Recommendation Report for Planning Permission

REF NO: EP/182/18/PL

LOCATION: 20 Lashmar Road
East Preston
BN16 1EY

PROPOSAL: 1 No. end of terrace house together with associated car parking, new vehicular access, garden shed & planting (resubmission following EP/148/17/PL).

Lashmar Road (West) Elevation

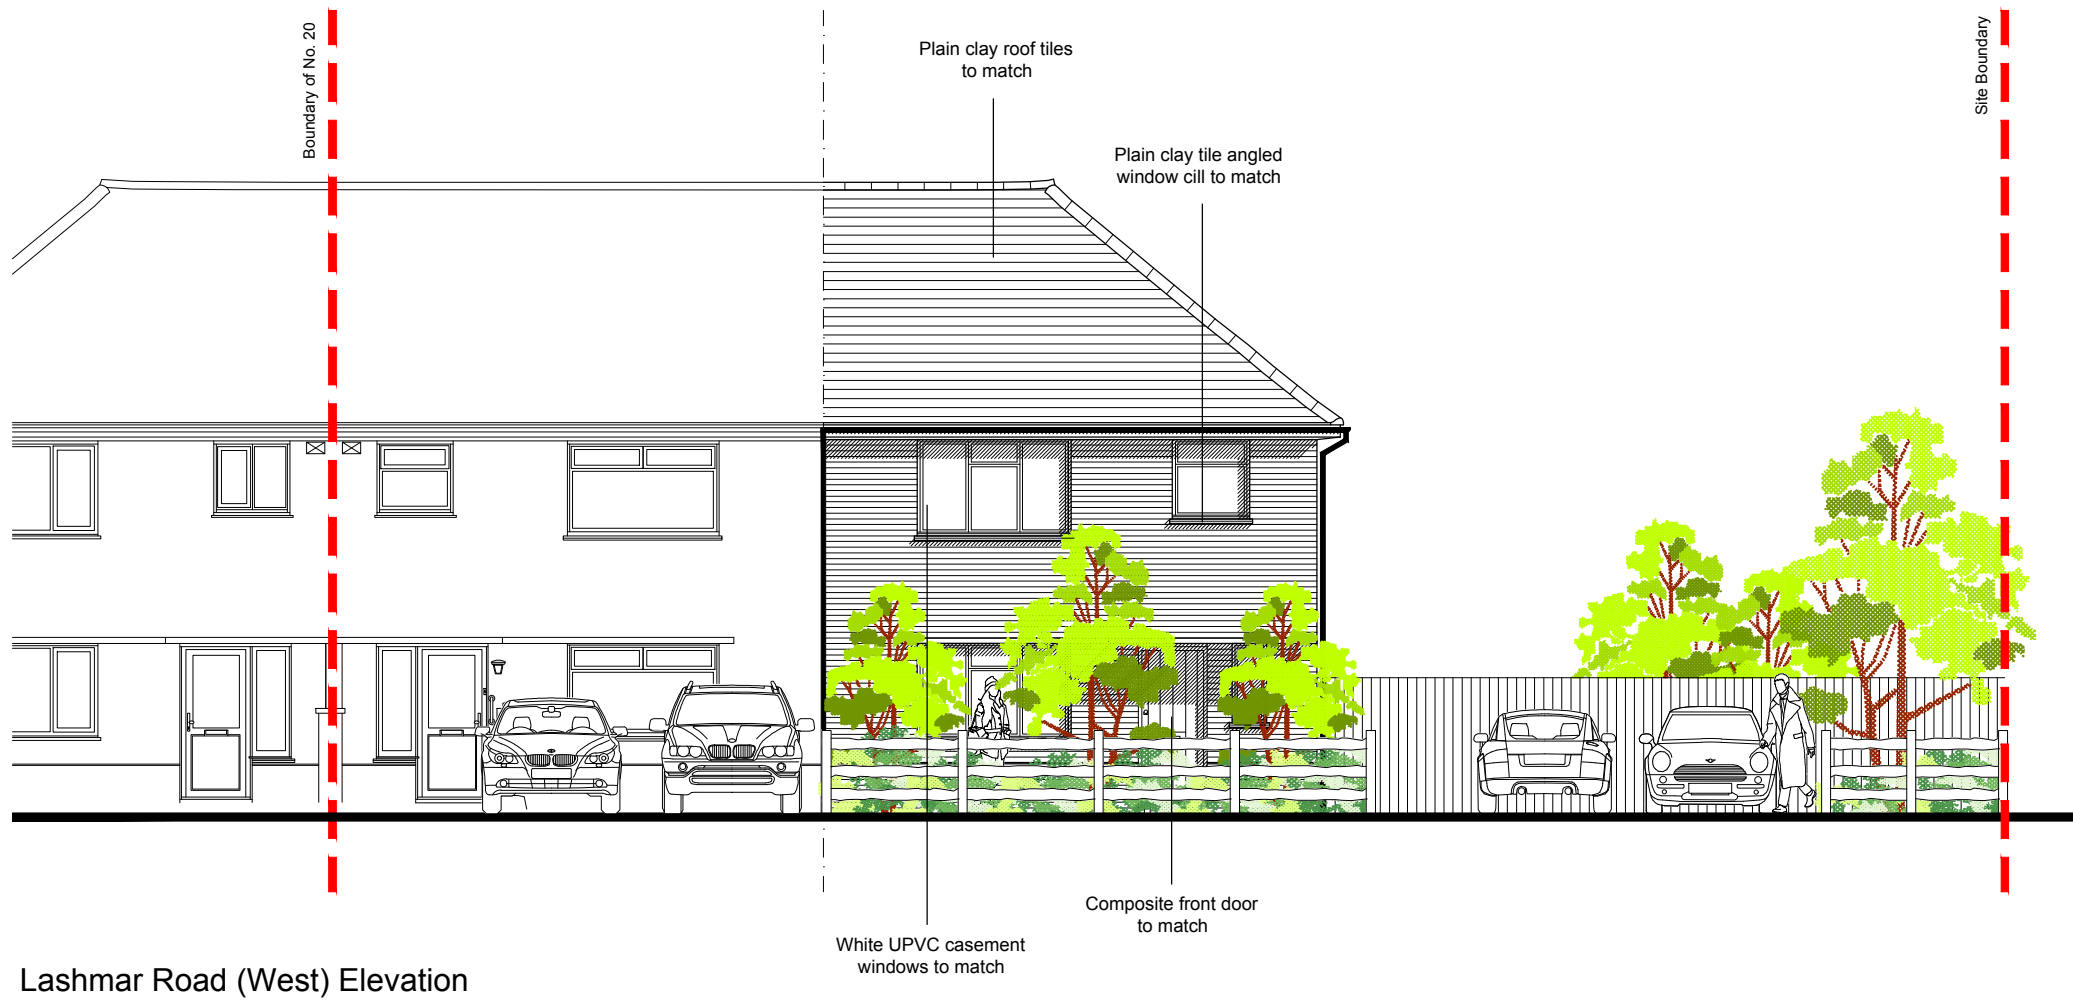
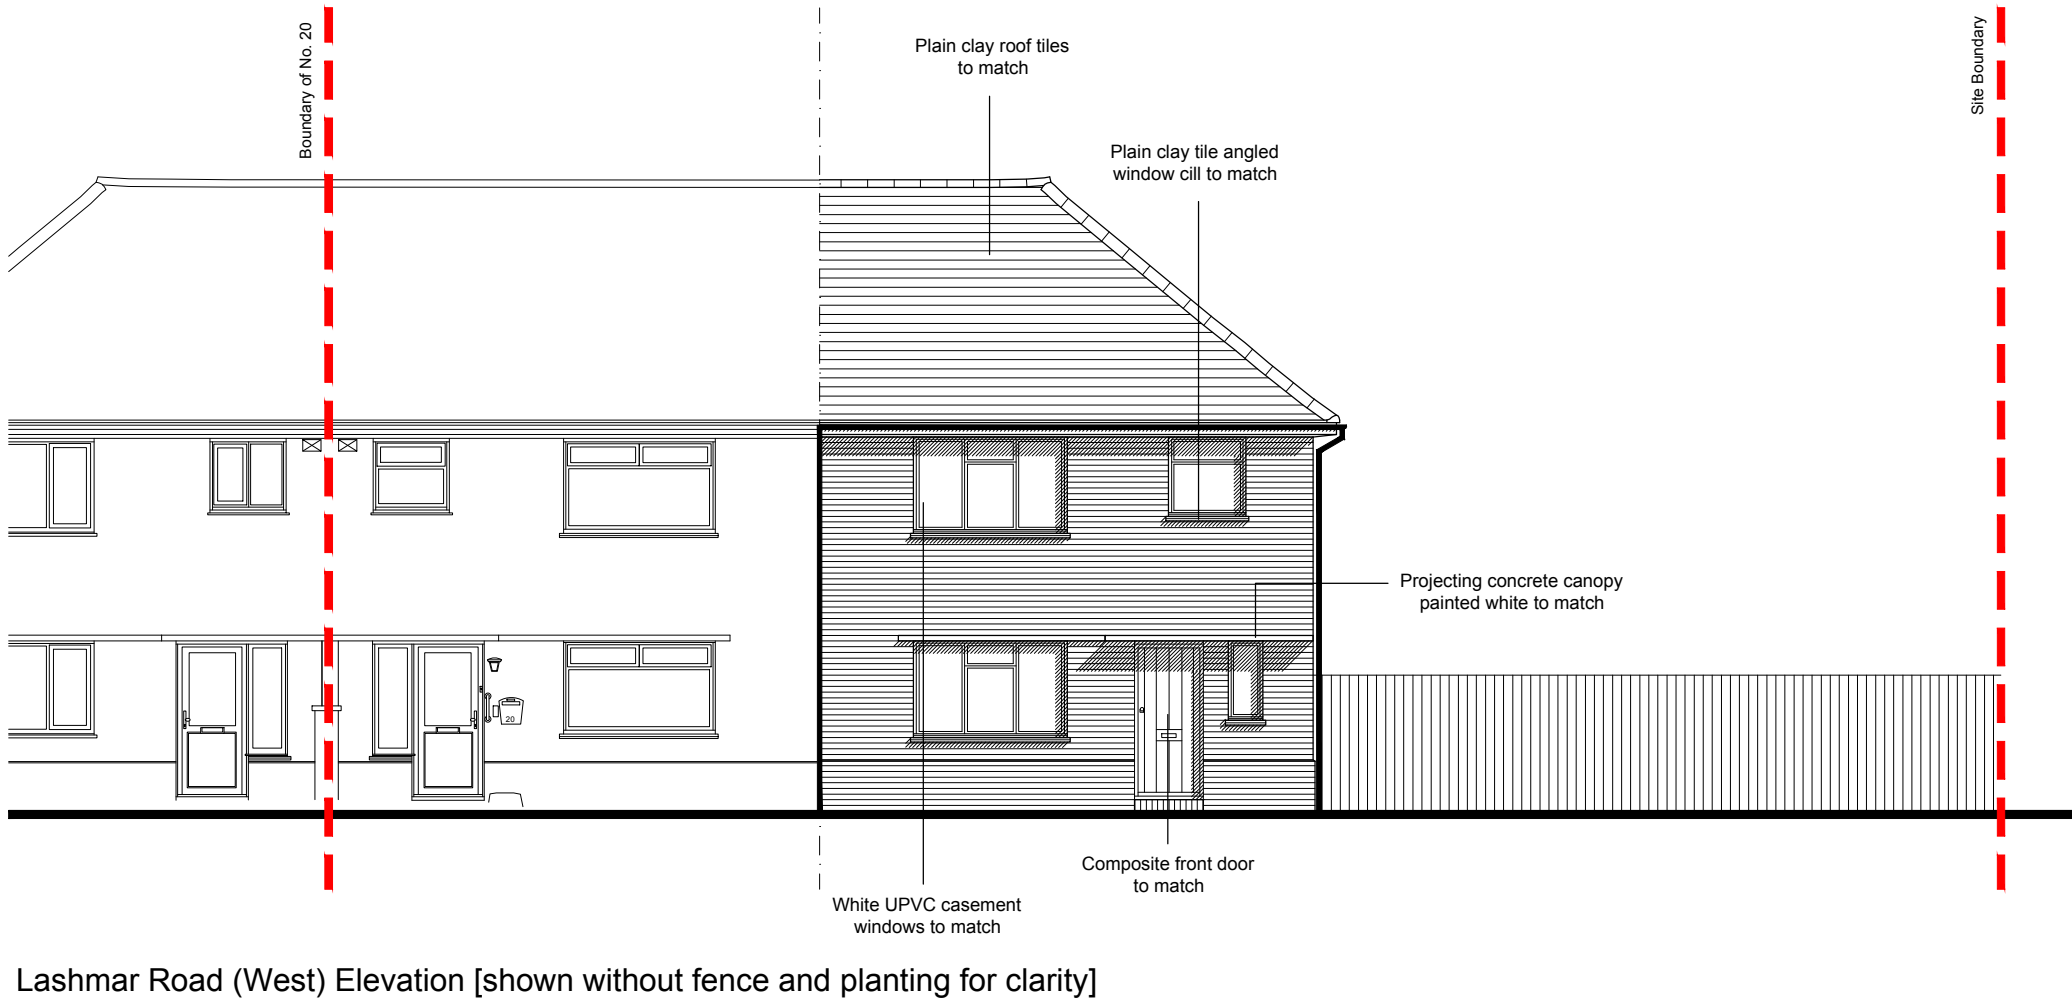
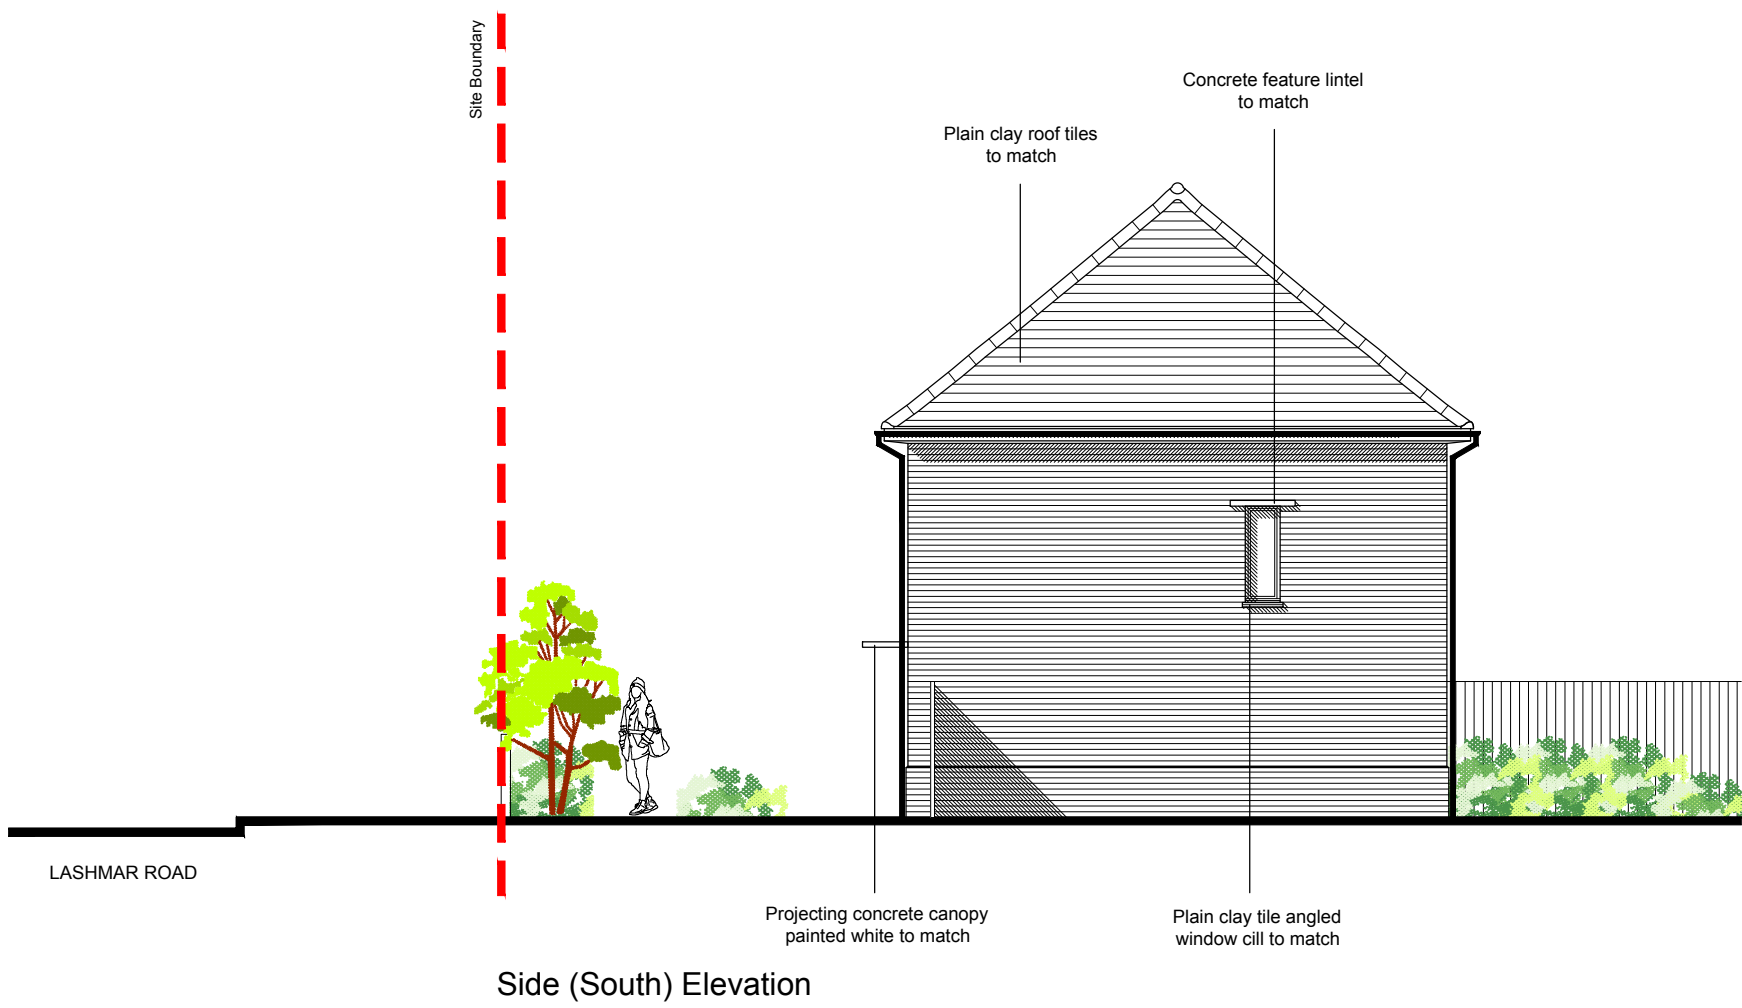
The proposed dwelling would replicate the design, height, mass and hipped roof shape of the existing

pair of semi detached houses such that it would blend into the street scene and have a sympathetic appearance including matching materials to the existing pair of semi detached dwellings.

The previously refused dwelling (EP/148/17/PL) that was dismissed at planning appeal had a number of features which did not match the pair of semi detached dwellings to which it would be attached such as a forward projecting gable end and a primary gable end roof which did not match the hipped roof of the existing semis. The changes have reduced the overly cramped and over developed appearance of the dwelling and the proposed design in this application, for the reasons set above, is considered acceptable.

Ground Floor Plan

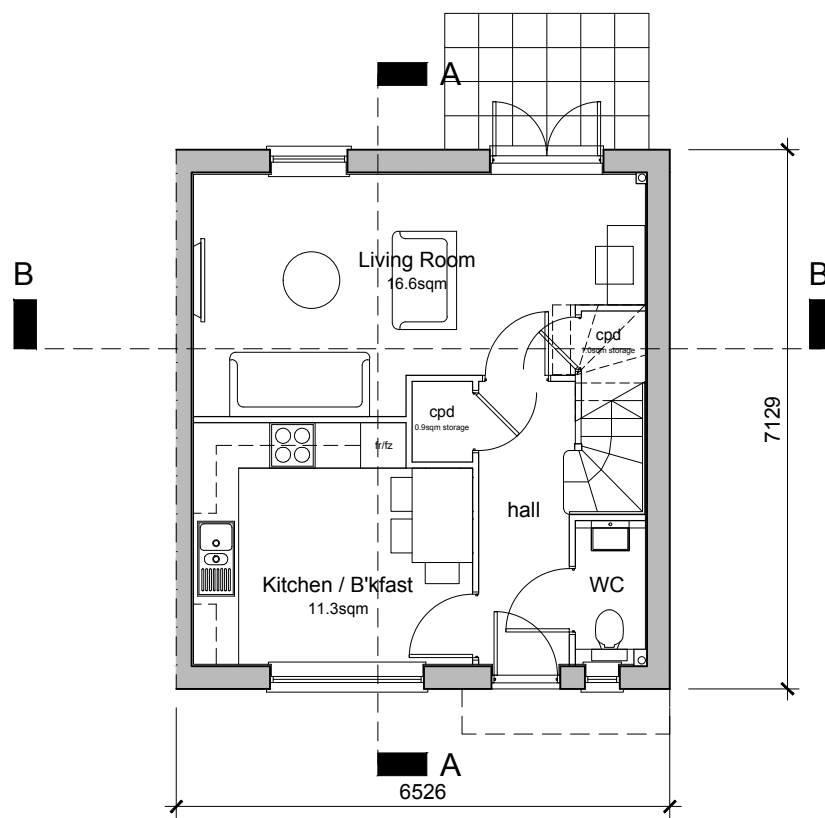
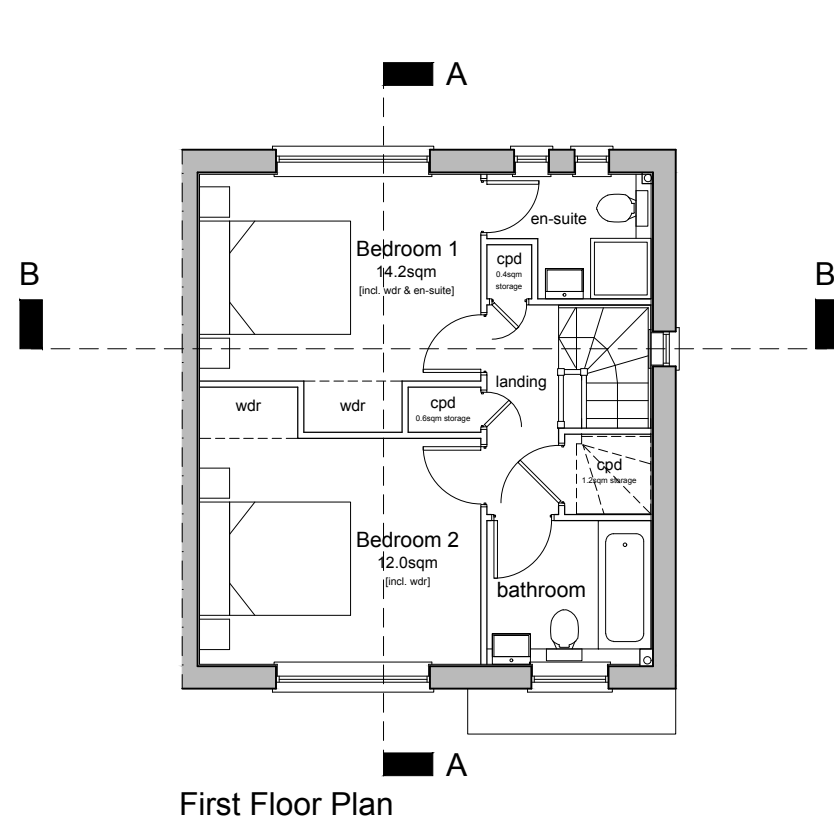
The proposed 2 bed 4 person dwelling would have a floor area of 79 sq.m. which meets the requirement of 79 sq.m. specified within the Nationally Described Space Standards. The proposal therefore complies with policy D DM2 of the Arun Local Plan with respect to internal space standard.
